**CONTOURED LOGO CABINET**

Customer: **NEXT GEAR**  
Address: **11852 STAPLETON DRIVE  
PEYTON, CO 80831**  
Contact: **BRAD EDWARDS  
(719)660-5855**

# Markup Summary

Elevation Drawing

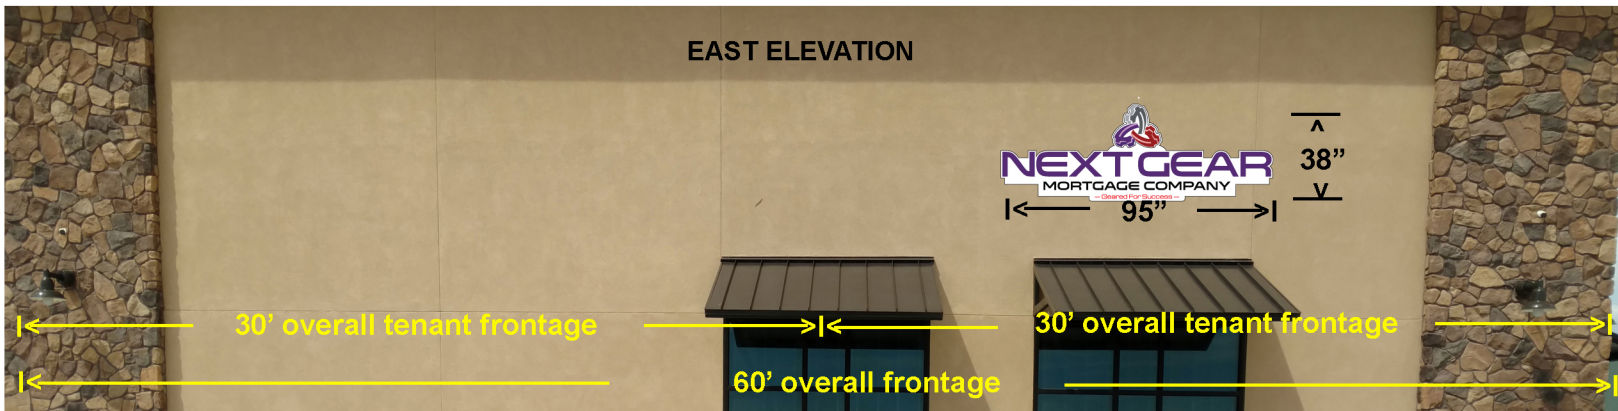
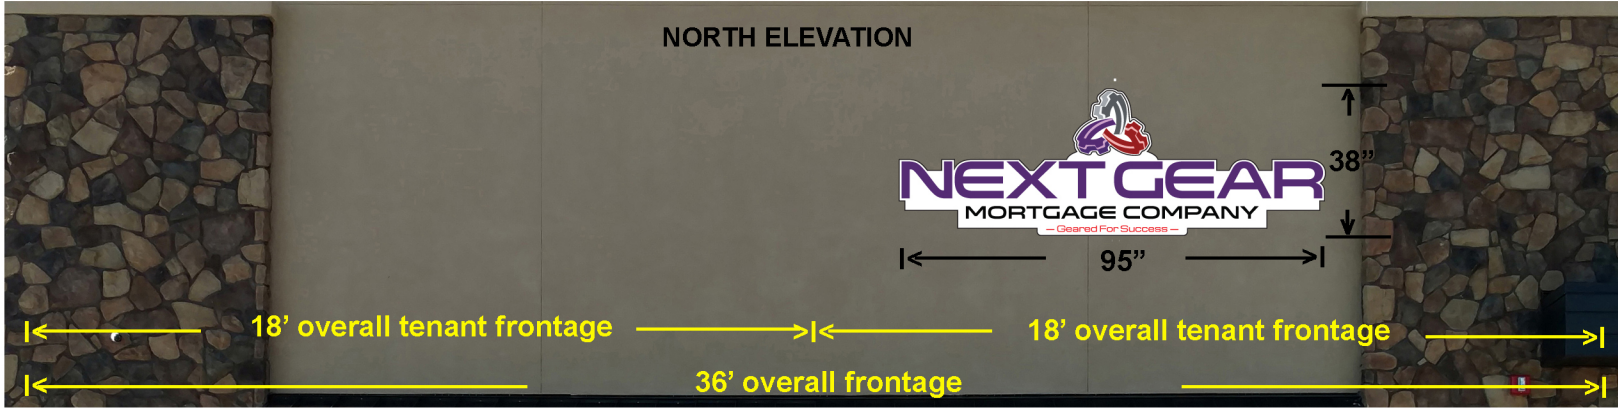
Show entire parcel, entire building, entire frontage of tenant, and where the signs are proposed on the structure.

CONTOURED LOGO CABINET

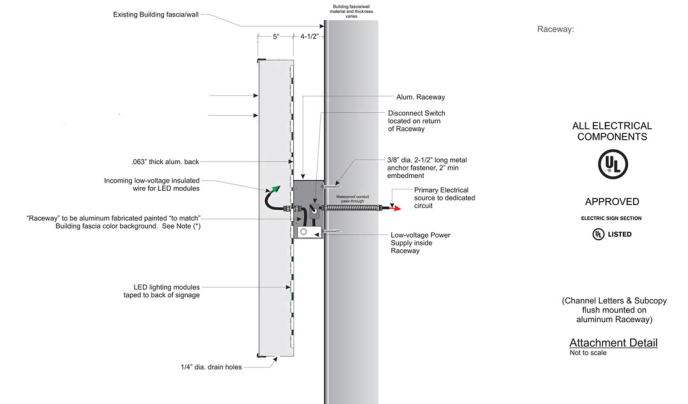
Include a note stating that the illumination meets criteria in El Paso County Land Development Code.
